# CITY OF ALBUQUERQUE

February 16, 2023

**RE: Take 5 Oil Change  
10415 Central Ave NE  
Grading and Drainage Plans  
Engineer's Stamp Date: 02/03/23  
Hydrology File: L21D059B**

GRADING/DRAINAGE NARRATIVE

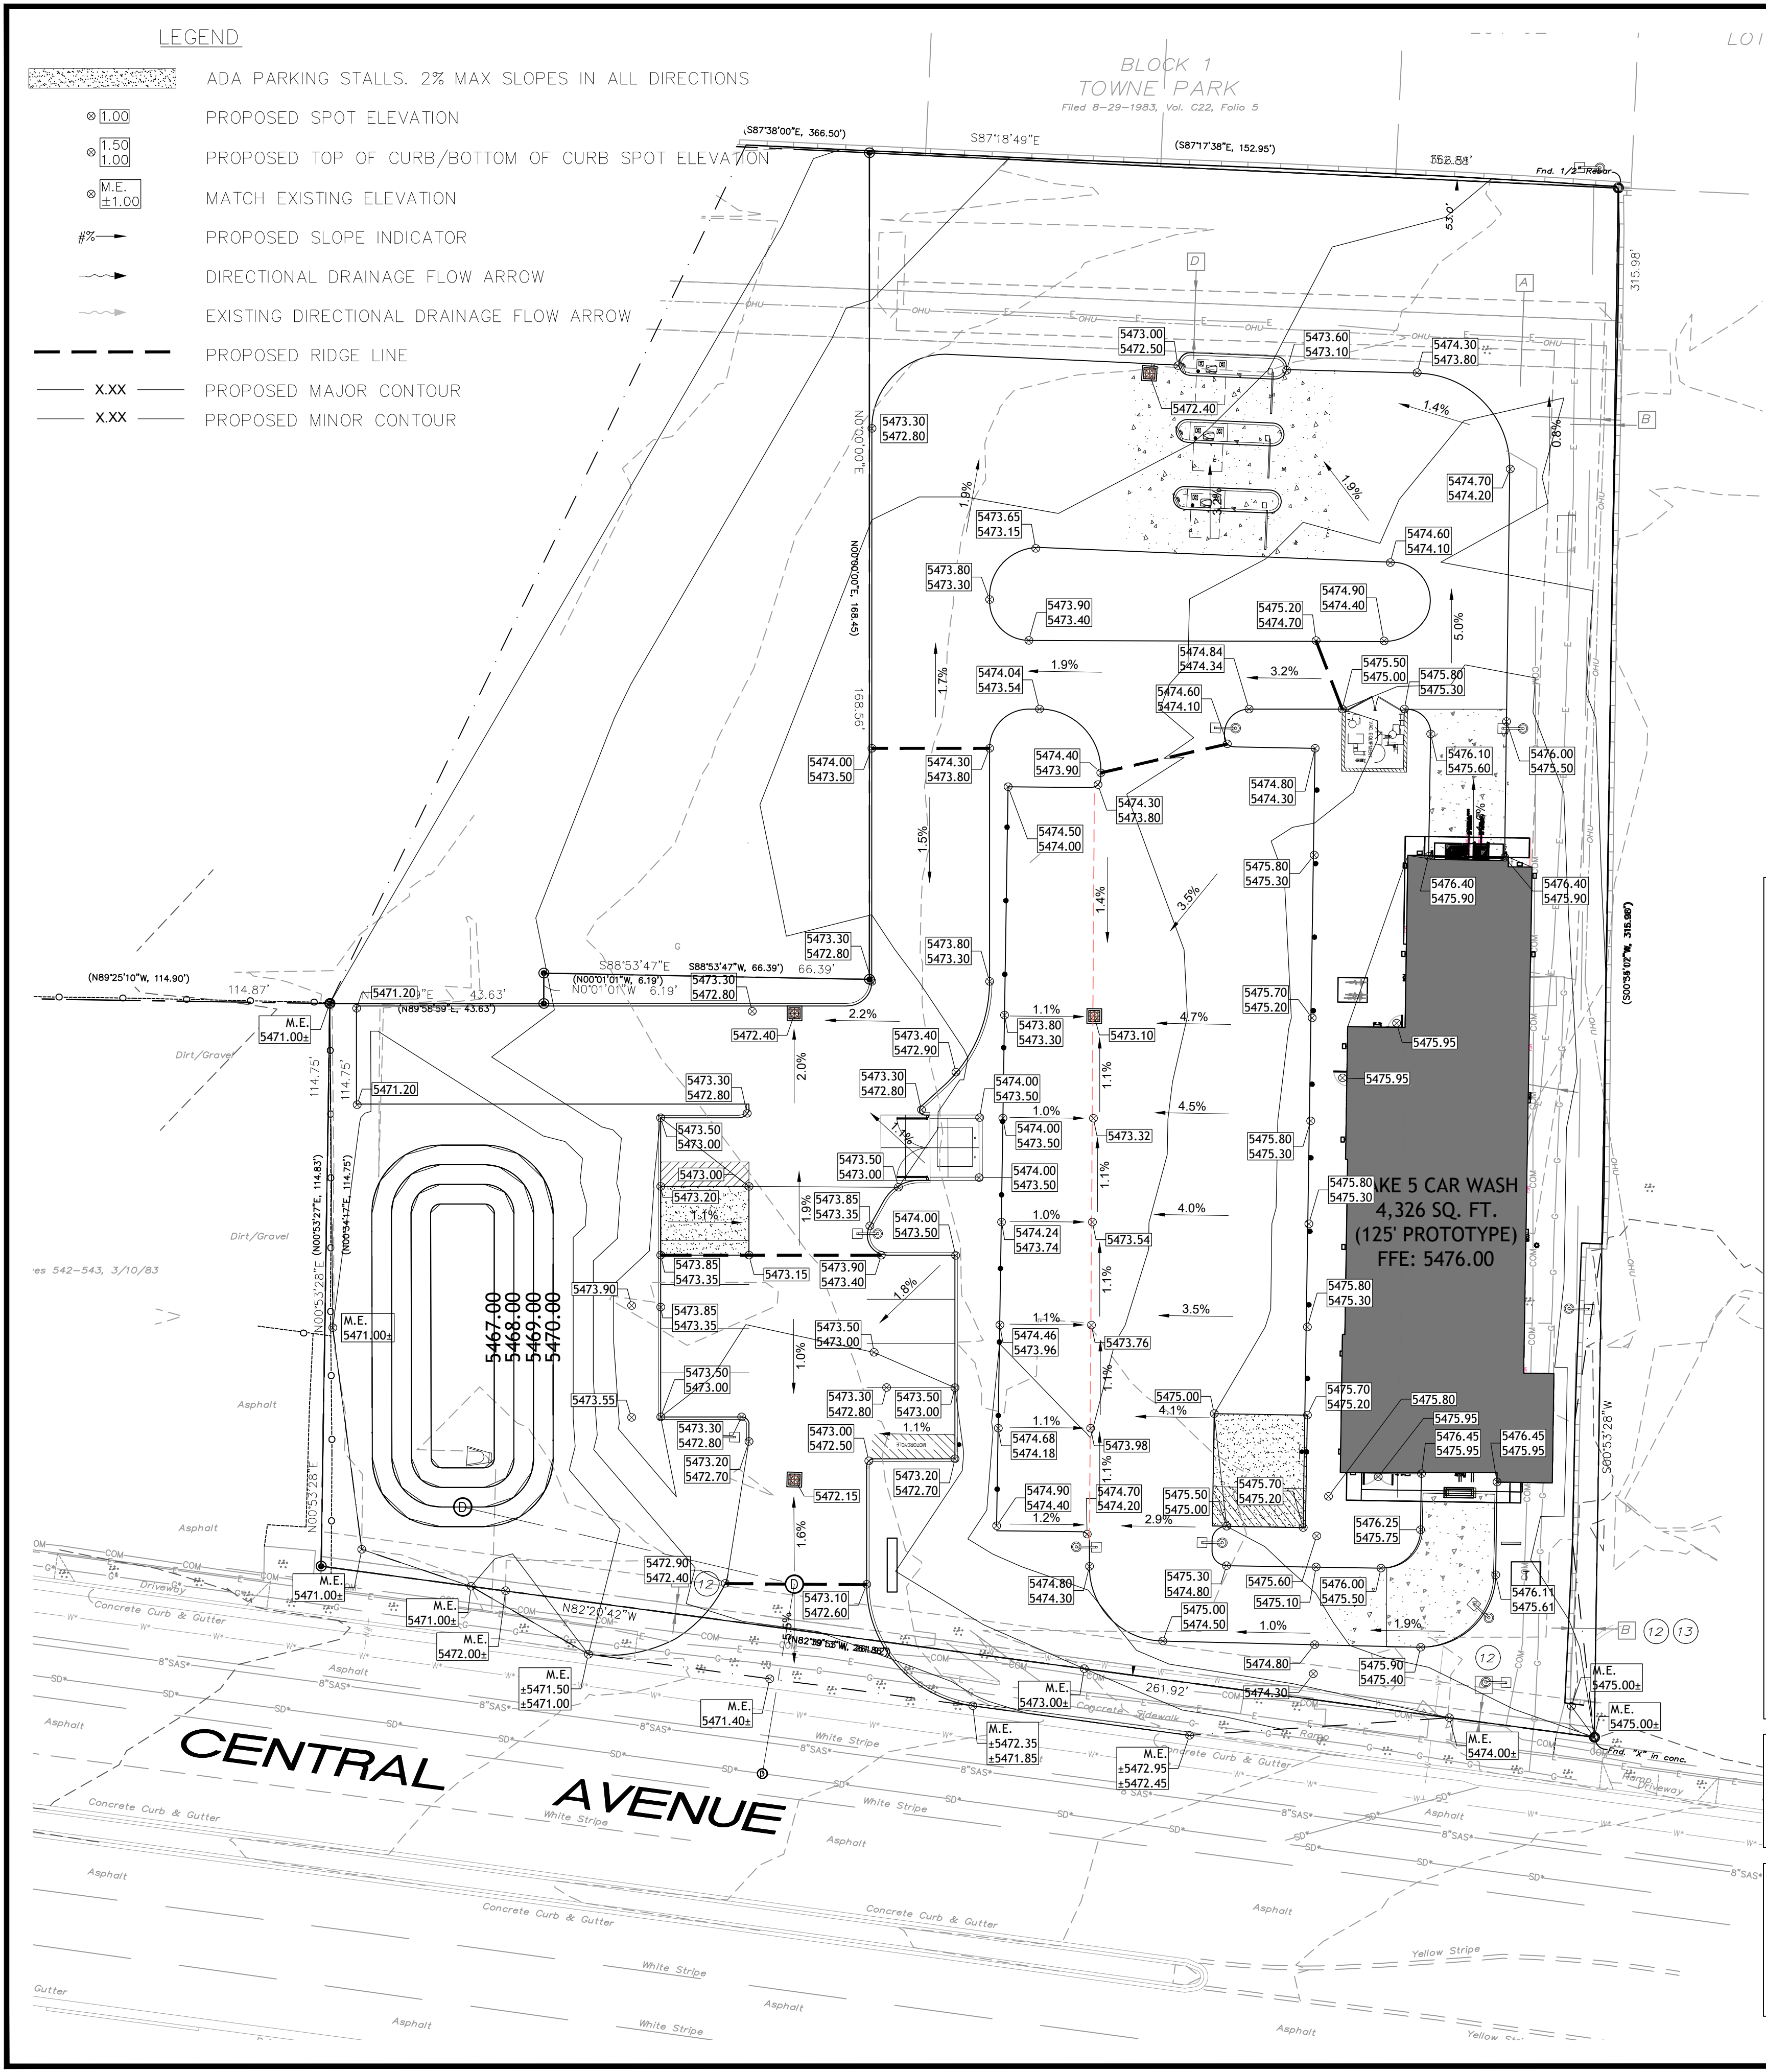
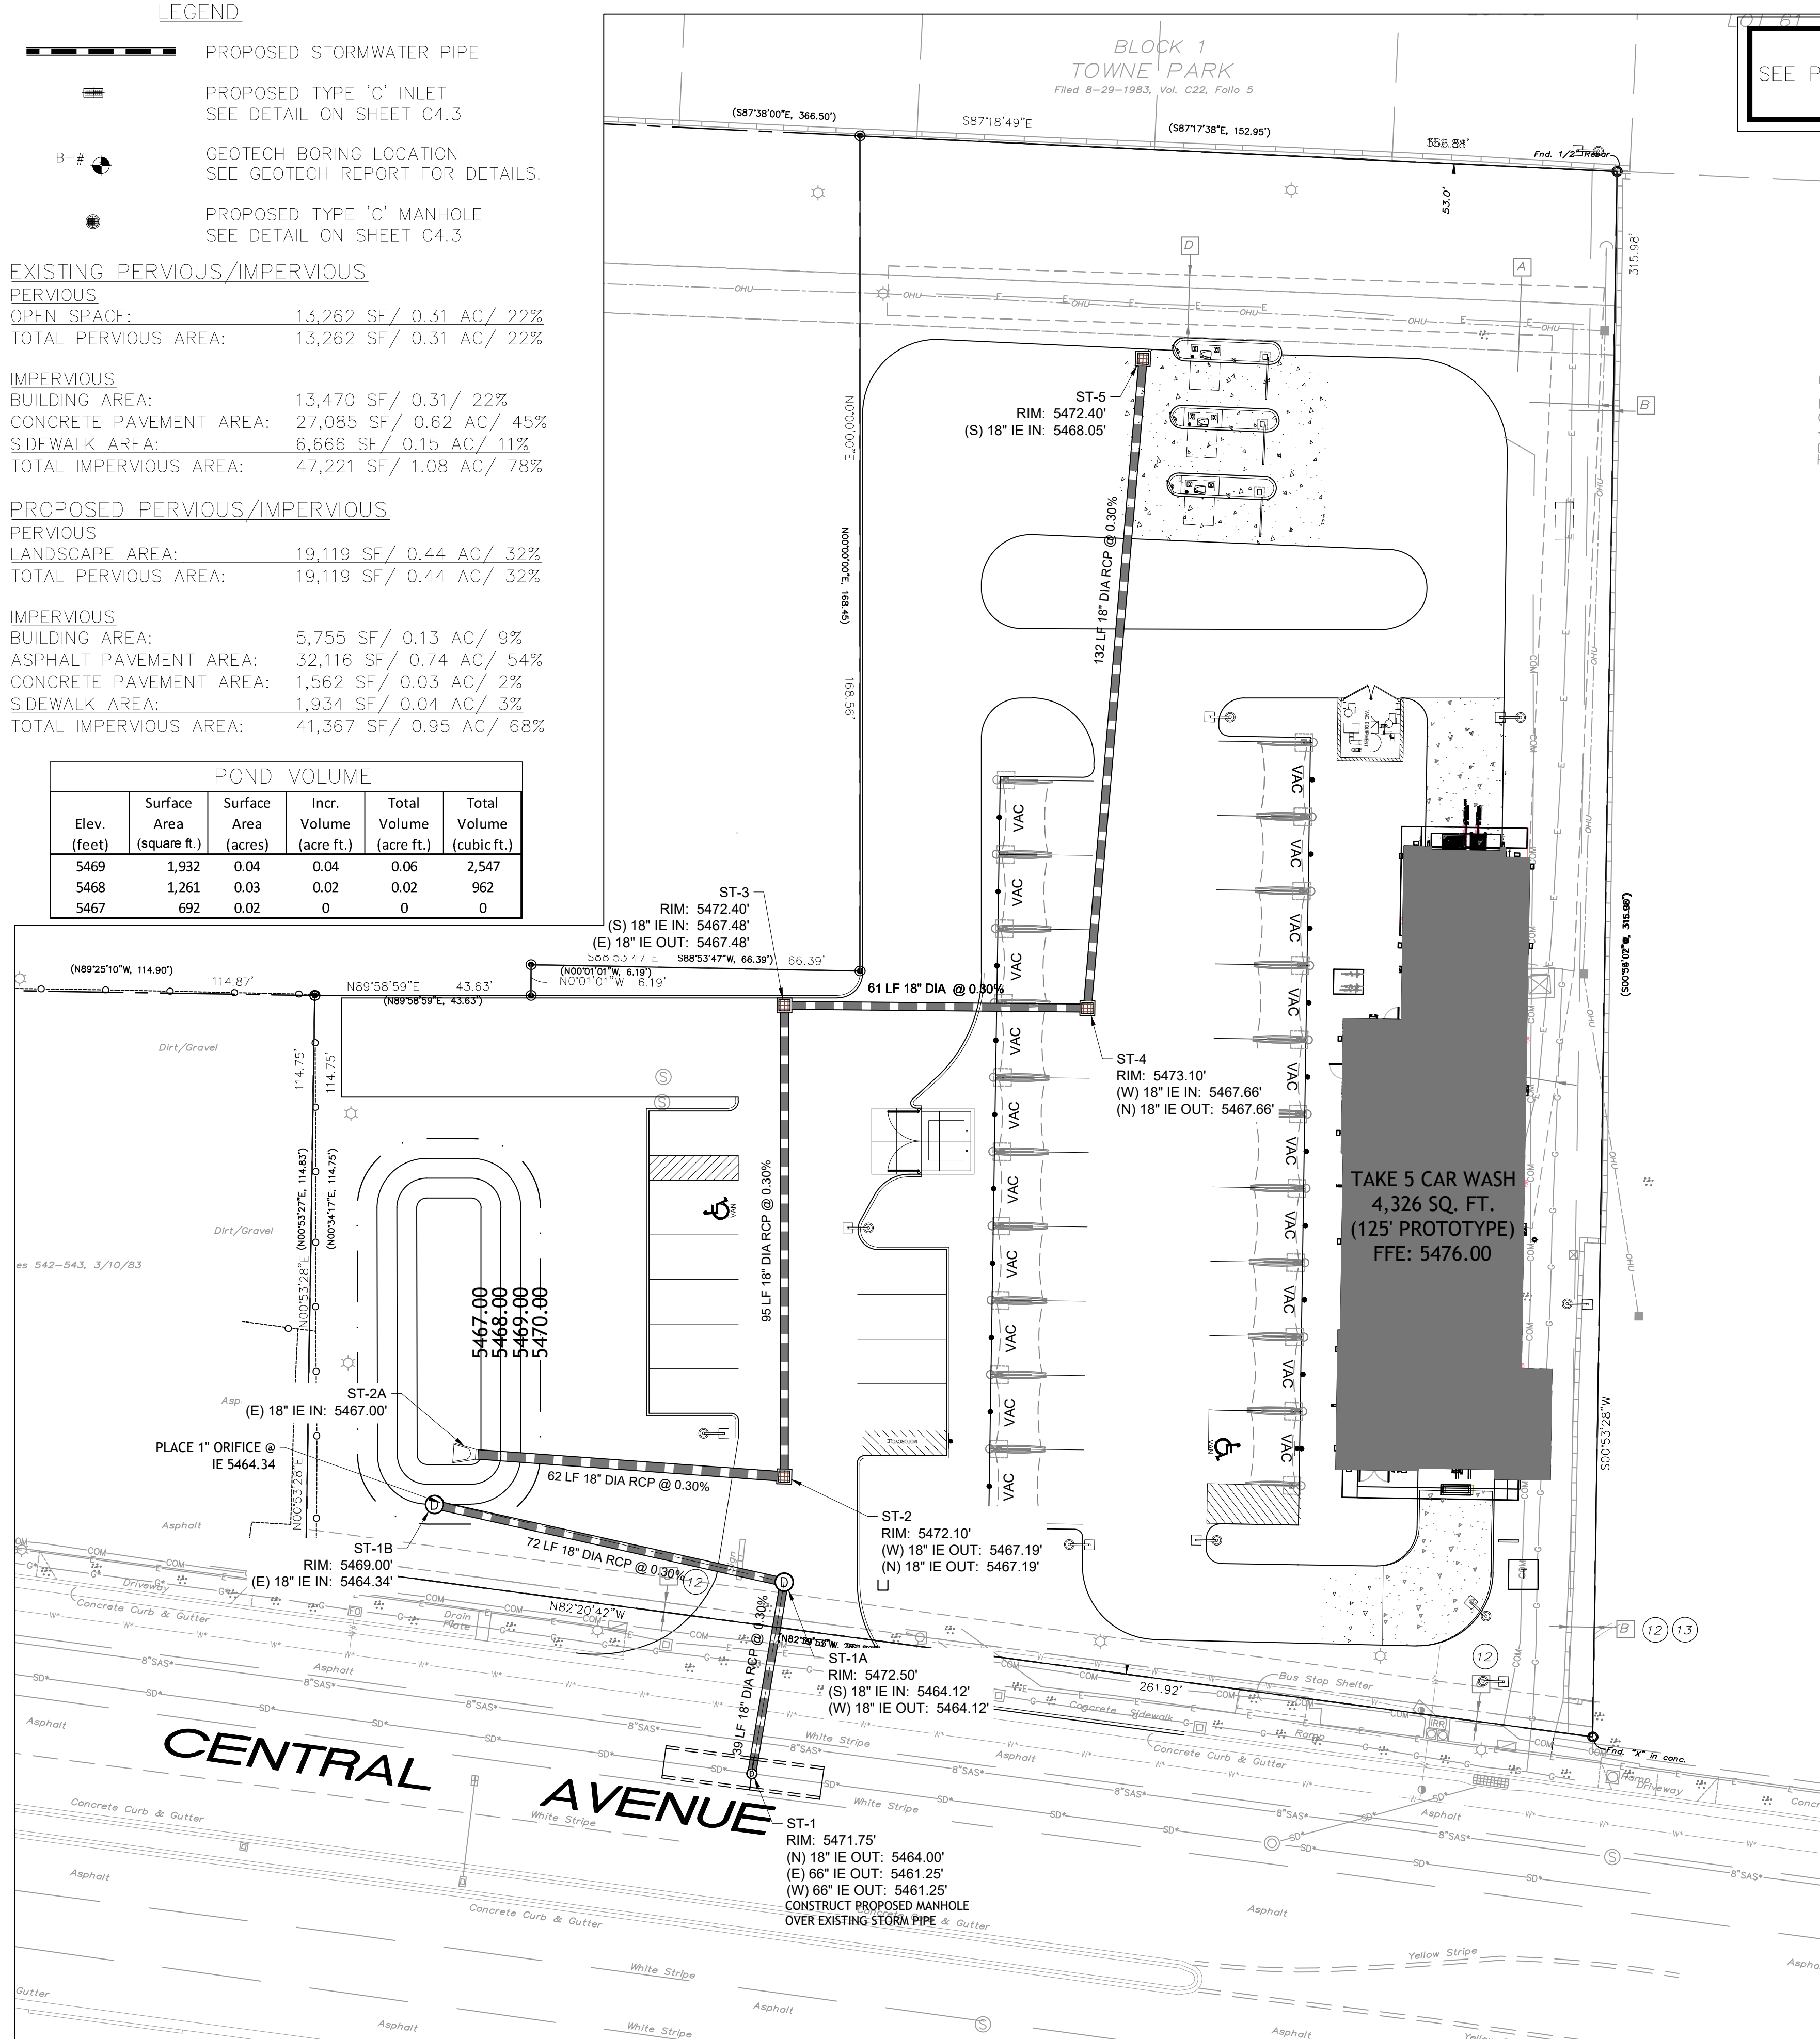
5. Please add the volume provided under the Stormwater Quality Calculations.

9. Please use the procedure for 40 acre and smaller basins as outlined in Development Process Manual (DPM) Article 6-2(a). Please provide both the existing conditions and proposed conditions for the 100 year-6 hour storm event. These calculations should be on the Drainage Plan.

**Response: Calculation has been added to the grading sheet C-4.0**

**Response: Refer to calculation added on the grading plan sheet C-4.0.**
